STERLING RANCH FILING 3 LANDSCAPE PLAN

LANDSCAPE NOTES & DETAILS

LANDSCAPE PLAN

landscap plan redline.pdf Markup Summary 3-24-2022

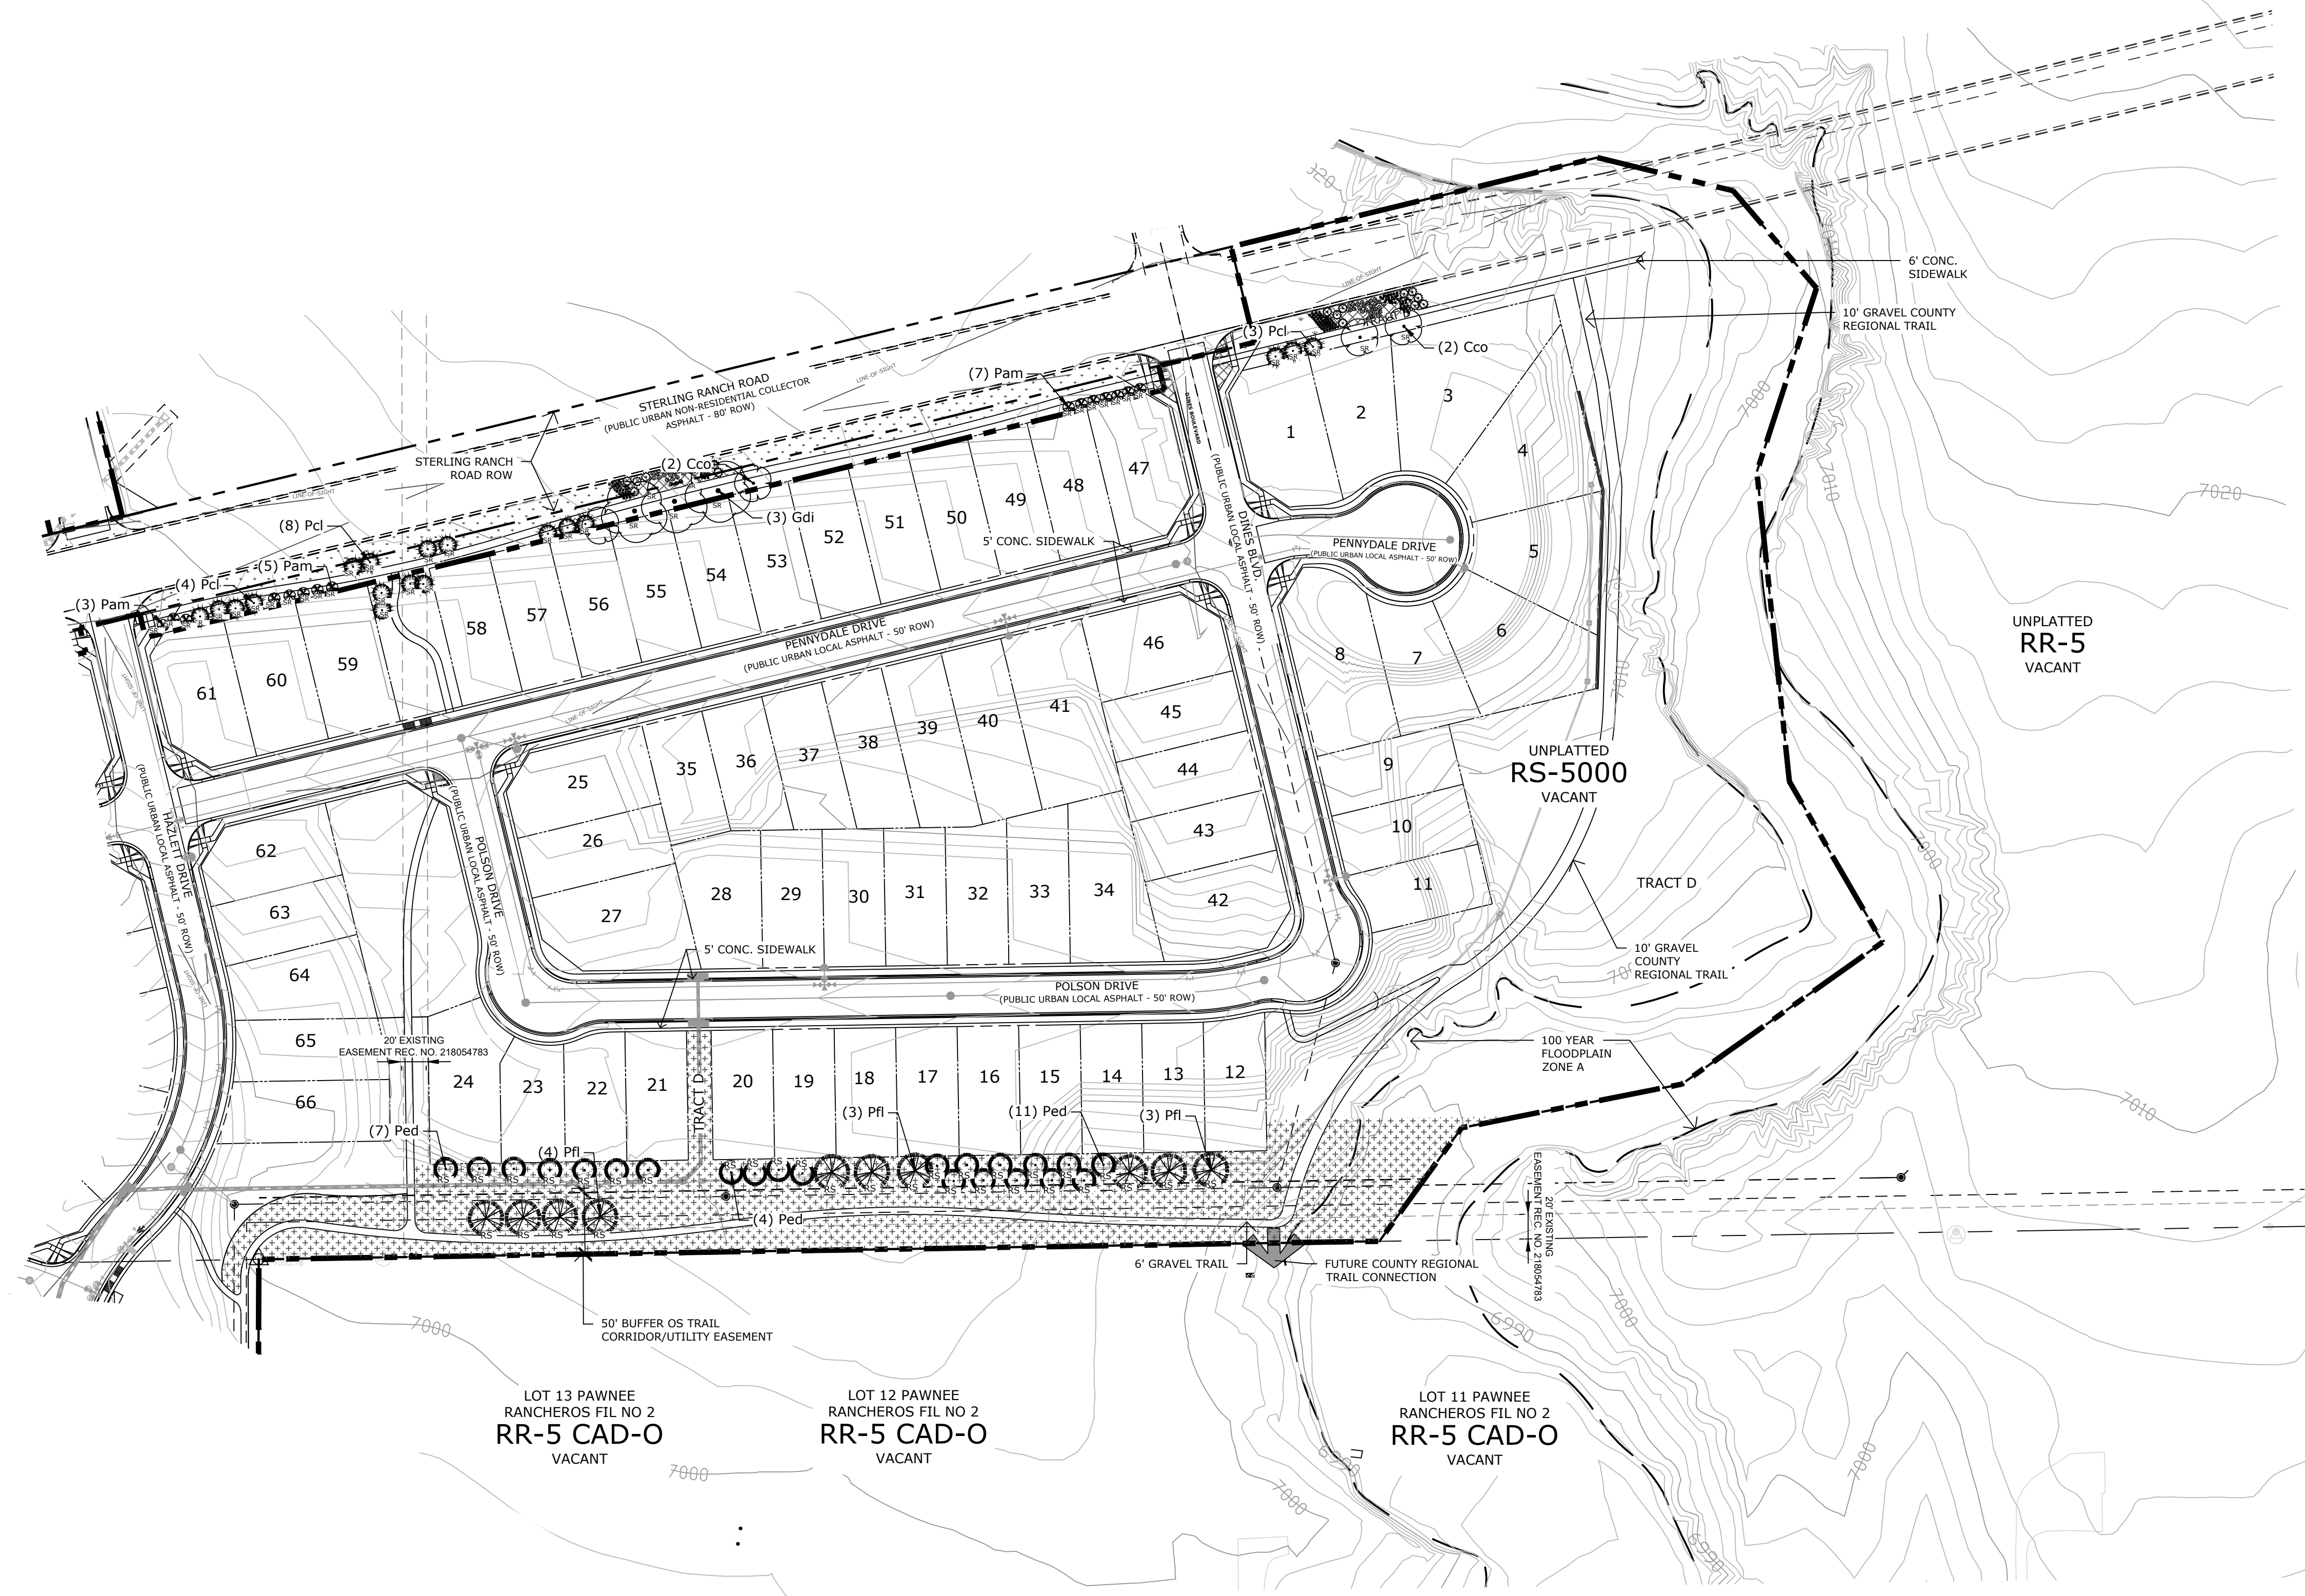
where does retaining wall go? Show.
